**Application by Highways England for the A1 in Northumberland: Morpeth to Ellingham  
The Examining Authority's written questions and requests for information (ExQ2)  
Issued on 19 March 2021.**

**Responses are due by Deadline 5: 1 April 2021.**

© WSP UK Ltd

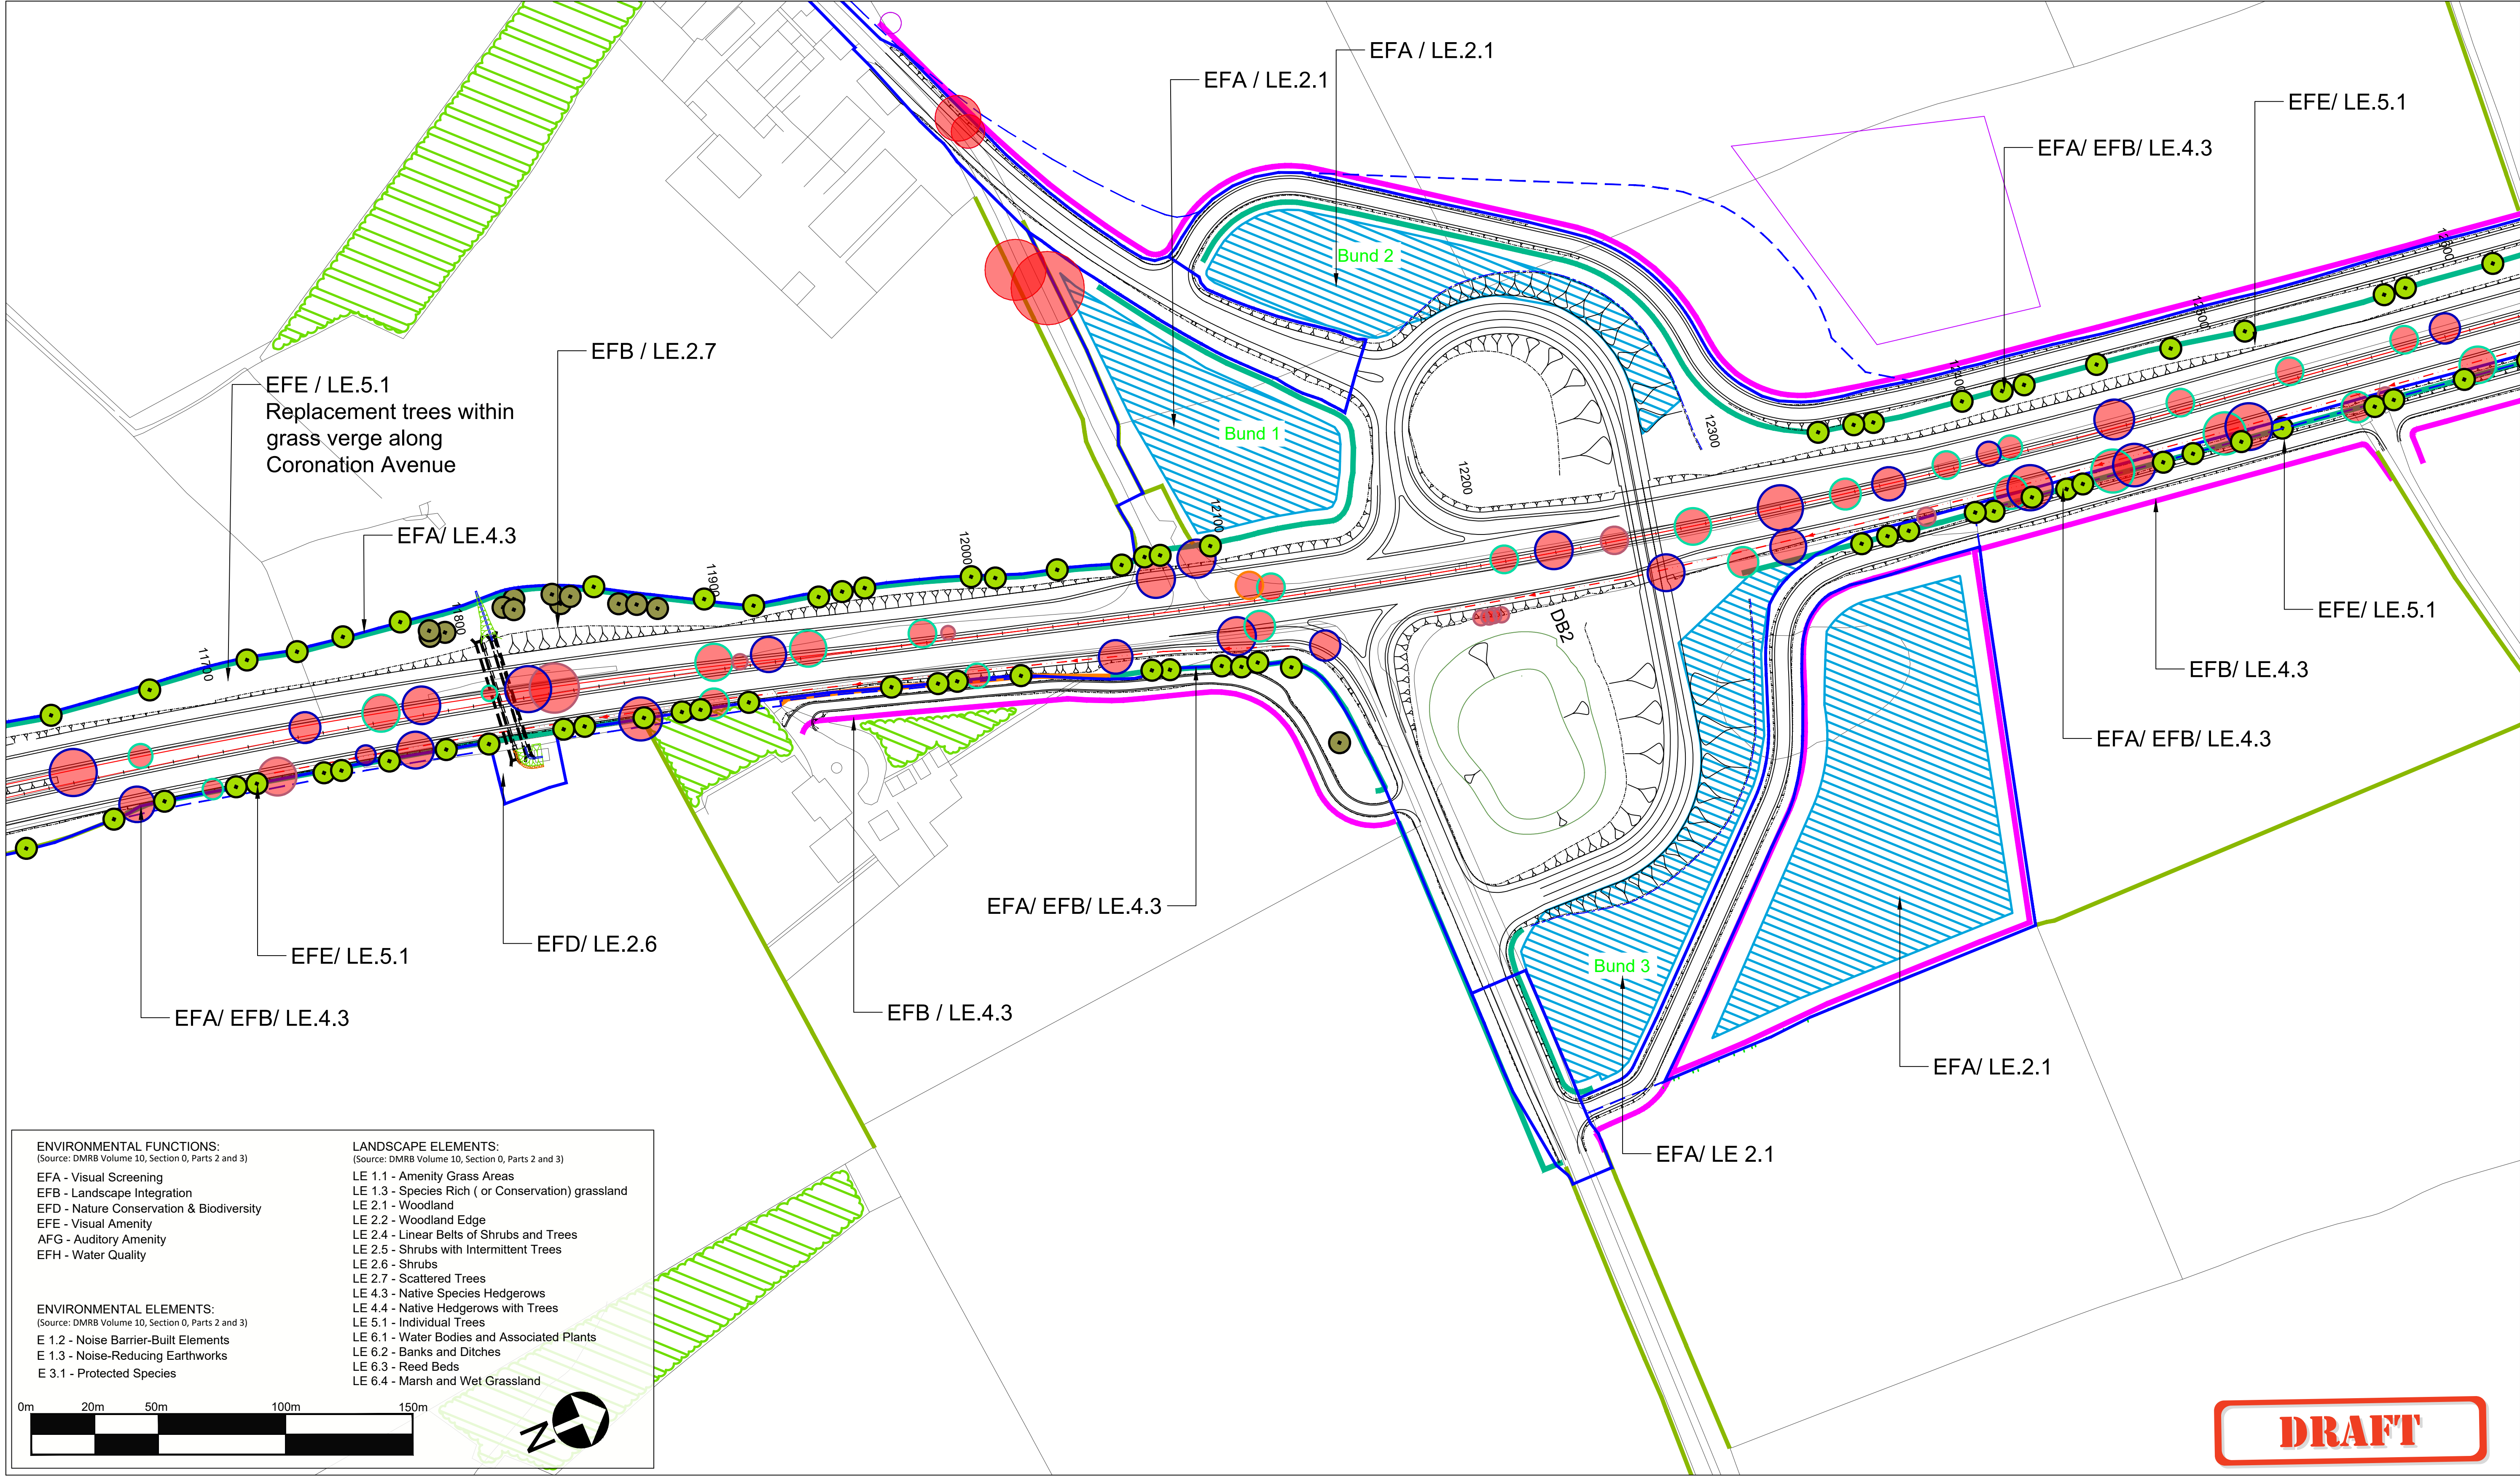
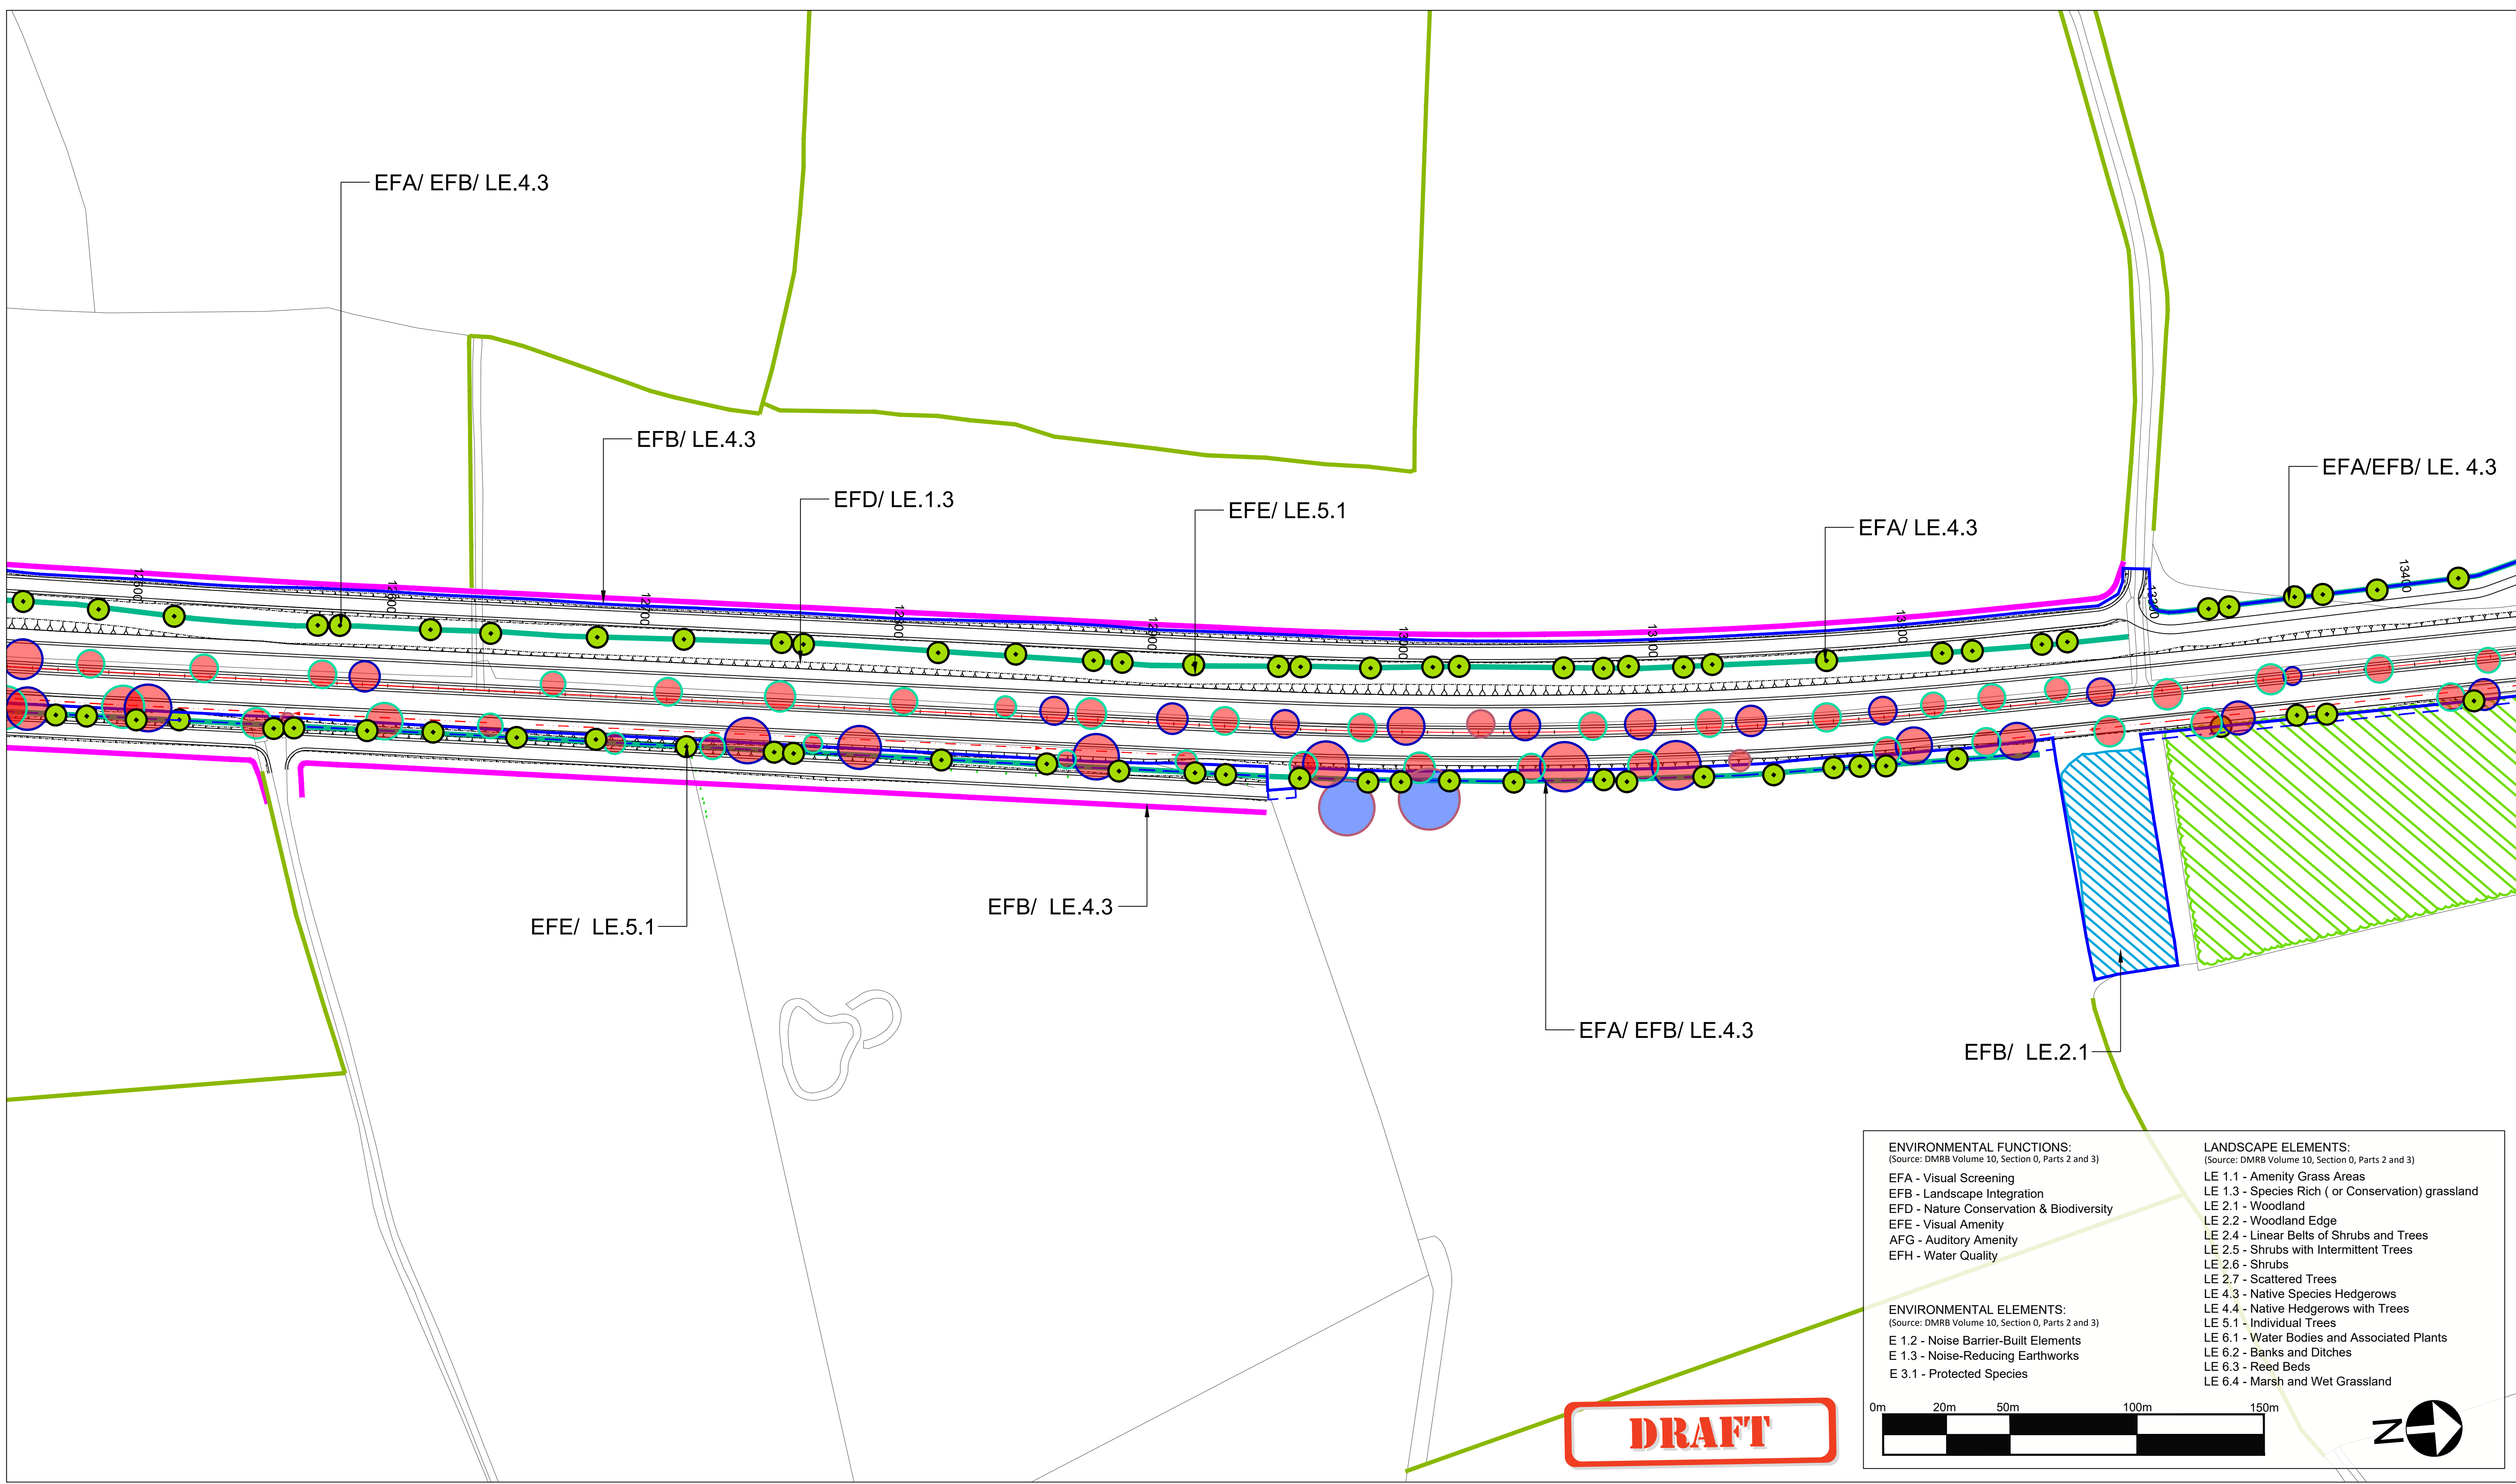
LV.2.2	Applicant IPs	The plans which form Appendix LV.2 Trees to be Removed and Replaced at Coronation Avenue WQ LV.1.8 [REP1-044] are annotated 'Draft'. The Applicant is asked to explain how this relates to the requirement in R5(3) of the dDCO for the landscaping scheme to include a strategy for the replacement of trees which are to be removed at Coronation Avenue? IPs are asked to comment on the proposals for Coronation Avenue.
